Reference: H16-0376-18 **Date of Decision:** 25th June 2018
Applicant: Mr & Mrs Swift
240 Park Road
Spalding
Lincs
PE11 1QZ

Location: 240 Park Road Spalding
Description: Side-extension and single-storey rear extension

South Holland District Council hereby give notice that this application has been REFUSED for the above proposal for the following reason(s):

proposed ground floor

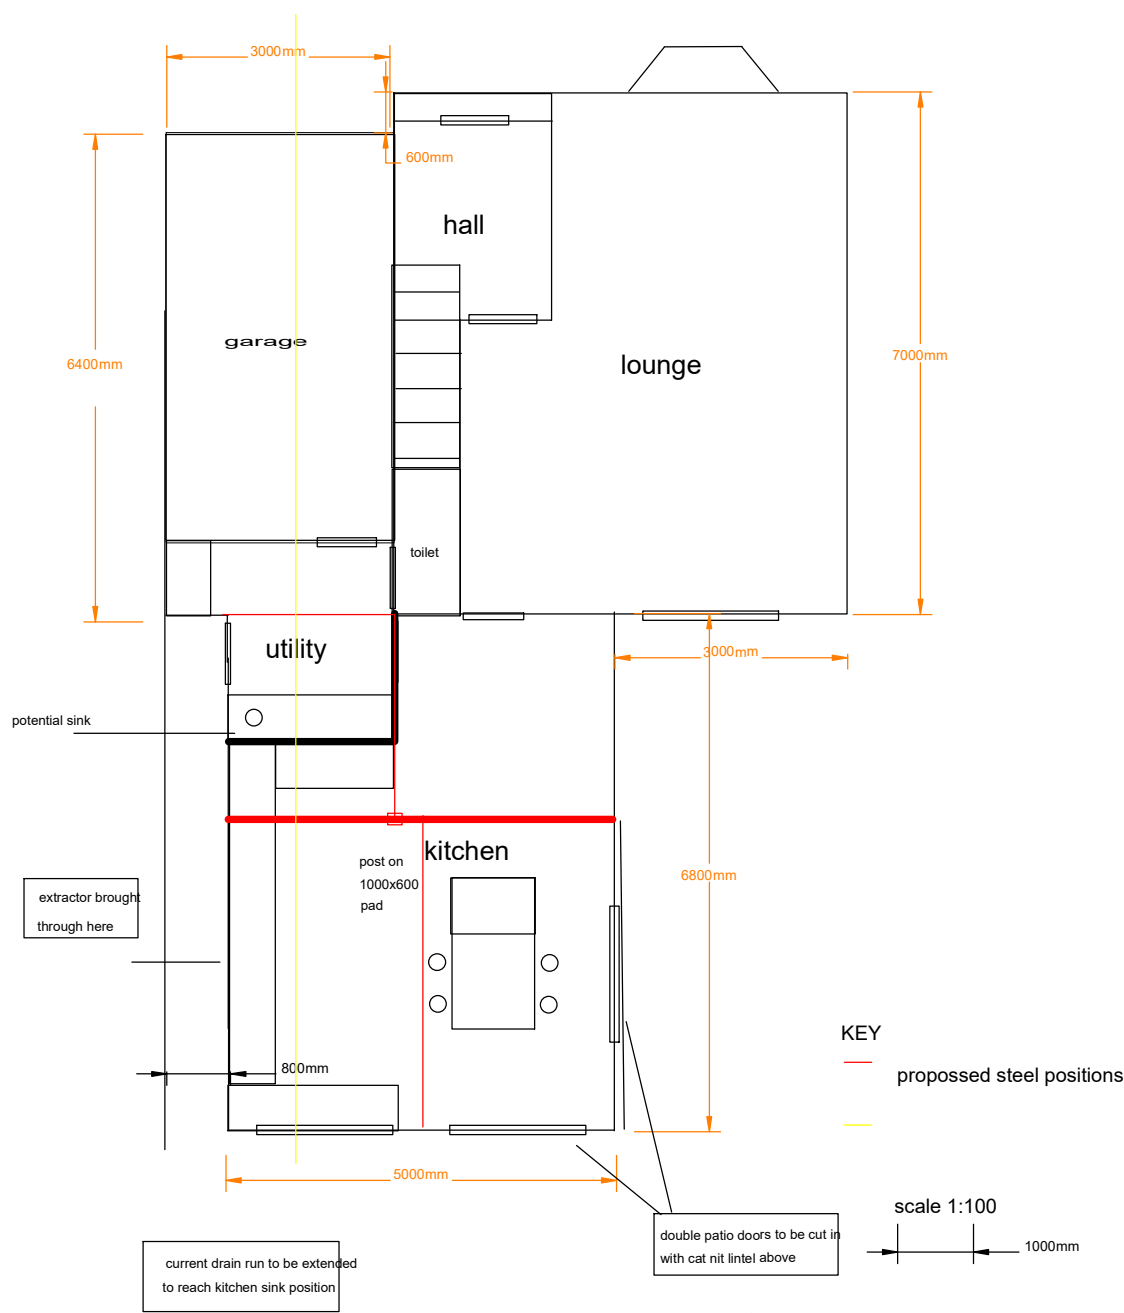
- 1 The two-storey element of the proposals would sit very close to the nearest neighbour at 242 Park Road and would cause a detrimental impact with regards to reducing light to the neighbour and cause a detrimental effect on the outlook from the property. The two-storey element would be imposing on the Conservatory area of the property and although the benefits of extending the dwelling for the family is clear, its negative effect on the neighbouring property, on balance is unacceptable.
